**Application Reference: 2025/0239****Site Address:** 20 Taylor Crescent, Grimethorpe, Barnsley, S72 7NU**Introduction:**

This application seeks full planning permission for a Single storey front porch extension and 2 storey rear extension to dwelling.

Drawing Title **PROPOSED PLANS**

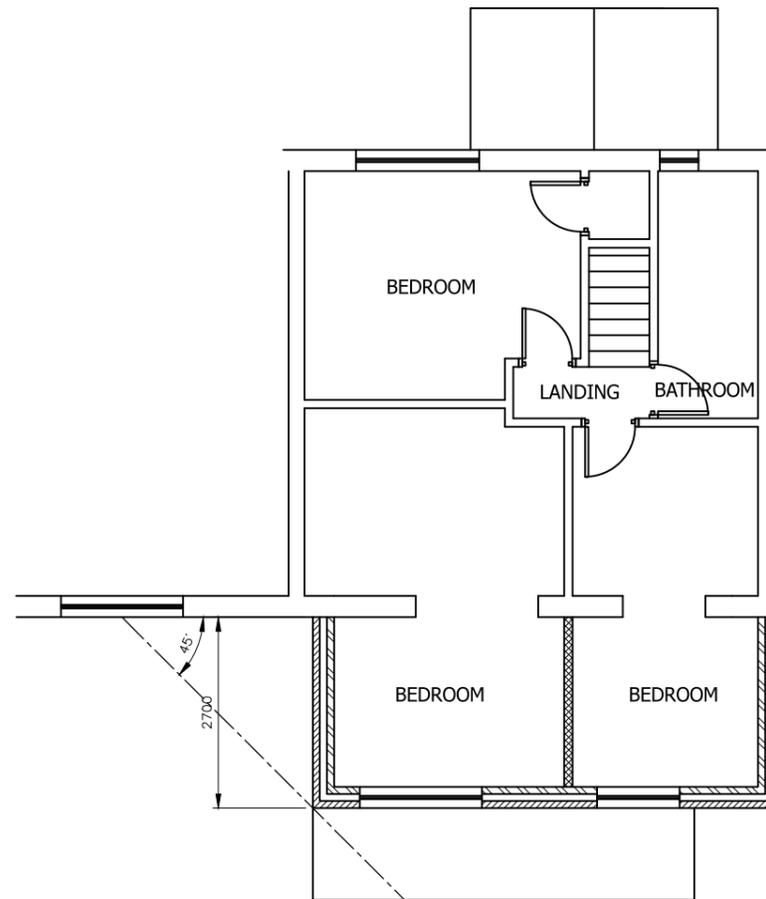
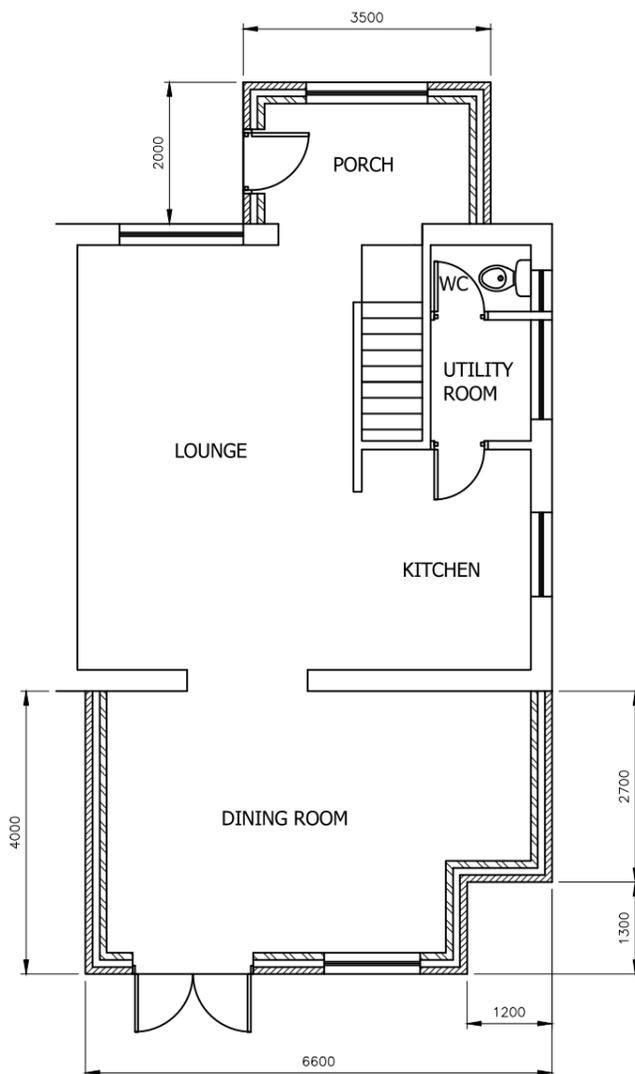
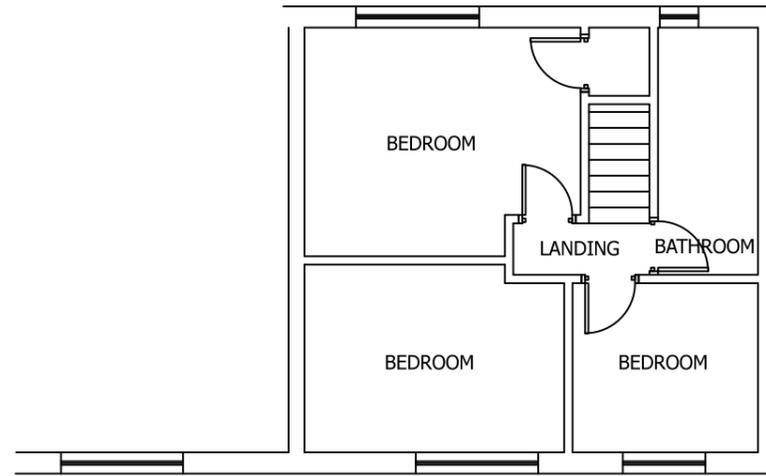
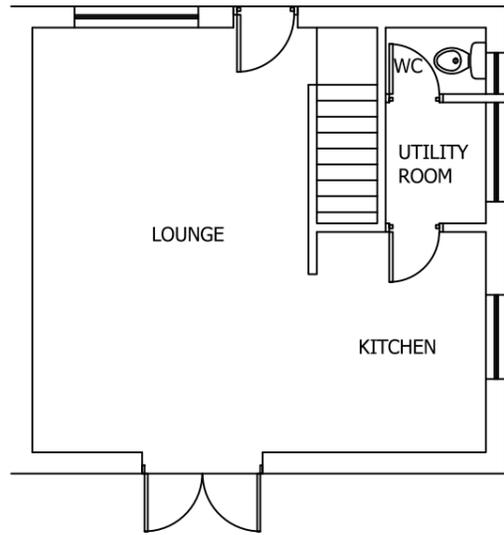
The proposal is constructed almost up to the boundary line with the attached neighbouring dwelling, which is allowed, although if the proposal was constructed through permitted development, a maximum eaves height of 3m, when located within 2m of a boundary treatment

would apply. As this is a planning application, part of the assessment uses the 45-degree rule. On this occasion, whilst the two-story aspect of the proposal does meet the 45-degree rule, the ground floor aspect of the extension slightly breaches it. In mitigation of this slight breach, the extension overall appears to have been considerably designed to minimise the impact on neighbouring amenity, and a request to in effect cut the corner off the extension to comply with policy would seem unjust when the resulting reduction would have a relatively insignificant improvement on amenity for the occupant's of the neighbouring dwelling who did not object to the proposal. In overall consideration of the extension, the negative impact on the amenity of the attached neighbouring dwelling would be considered as modest.

The proposed rear extension does not fully comply with guidance in the House Extensions and Other Domestic Extensions SPD, which indicates that first-floor windows should be located at least 10m from the rear boundary, and that two storey extension should not exceed a projection of 3.5m. Mitigation for this proposal arises that the rear boundary borders an area allocated as allotments but does not appear to be used for such a purpose. The residential dwellings beyond are more than the 21m distance required between windows. Whilst the whole extension has a 4m projection, the two-storey aspect is limited to 2.7m. These SPD requirements appear to be aimed at protecting residential amenity, but with no residential addresses immediately behind, the application dwelling, the impingement in relation to SPD guidance would have little or no effect on residential amenity.

Drawing Title
PROPOSED ELEVATIONS

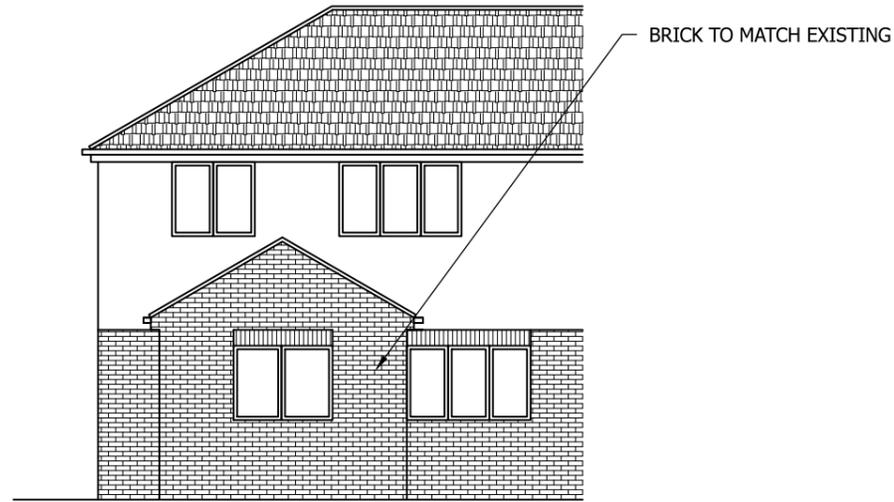
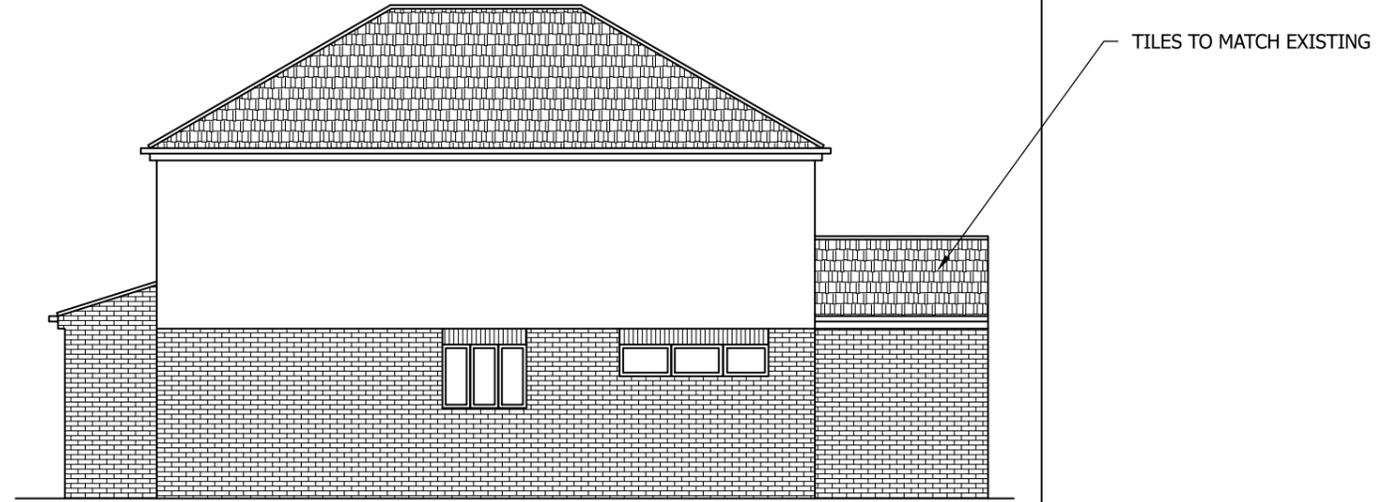
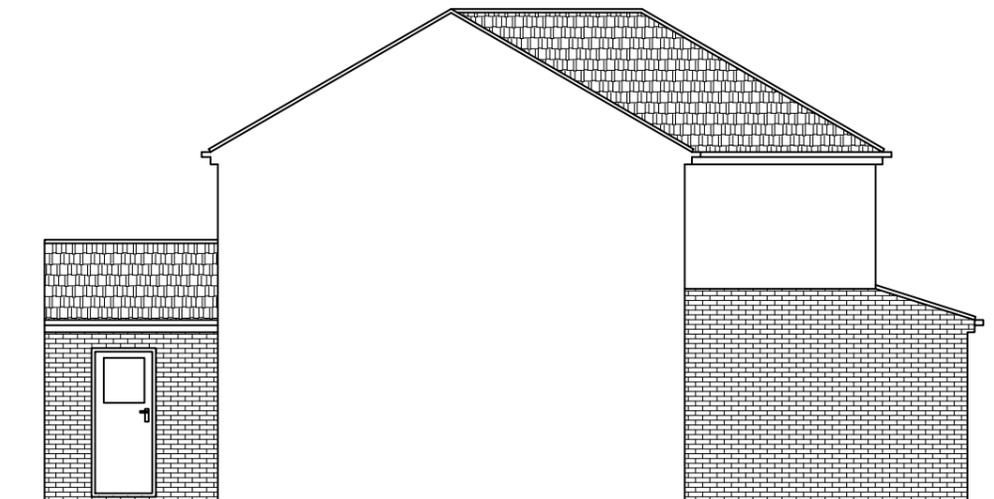
The eaves and ridge heights of the front extension would be approximately 2.4m and 3.7m respectively. The width and front projection would be approximately 3.5m and 2m respectively, with an approx. area of 7 sqm. The approximate eaves and ridge height of the two-storey section of the rear extension would be 4.8m and 6.98m, matching the existing roof, whilst for the single story would section feature an eaves and roof height of approx. 2.4m and 3.07m respectively.

The total rear projection of the extension would be 4m, but only 2.7m of this would be two-storey,

The proposed front porch extension is significantly larger than one which may otherwise be allowed through permitted development and would be quite dominant within the street scene. However, whilst such a large front extension would not usually be allowed on the front elevation of such a dwelling, on this occasion and principally due to the numerous and varied style and size of front extensions within the street scene and broader area, which have been either historically approved or constructed without due consent; it would be unjustified to refuse consent for this aspect of the application. Therefore, and only in this specific instance, the proposed front porch extension would be considered to have a limited impact on the scale, design and character of the dwelling and broader street scene.

In similarity to the front extension, the rear extension is quite large and given the dwelling's heightened position, and corner location, would be quite dominant within the wider street scene. In contrast to the extensions dominance within the wider street scene, it does remain reasonably proportionate in scale to the original dwelling and broadly meets current policy as outlined in the House Extensions and Other Domestic Extensions SPD.

Support in meeting SPD requirements arises from the limited projection of the two-storey aspect of the rear extension, at 2.7m, it is less than the maximum 3.5m which may have been acceptable, and with the additional single storey aspect extending the extension's total projection to 4m, this also meets the maximum guidance for a single storey extension to a semi-detached house. An eaves height of less than 2.5m for the single-story aspect of the extension, and a step in form the boundary on this aspect of the extension also aids in improving the overall scale and design of the proposal. In addition to the above, with required matching materials and a similar style roof for the two-story aspect, and a complementary style roof for the single storey aspect of the rear extension, visual amenity would be maintained to a reasonable degree, in accordance with Local Plan Policy D1 and the SPD, and the proposal would be considered as having a limited impact.
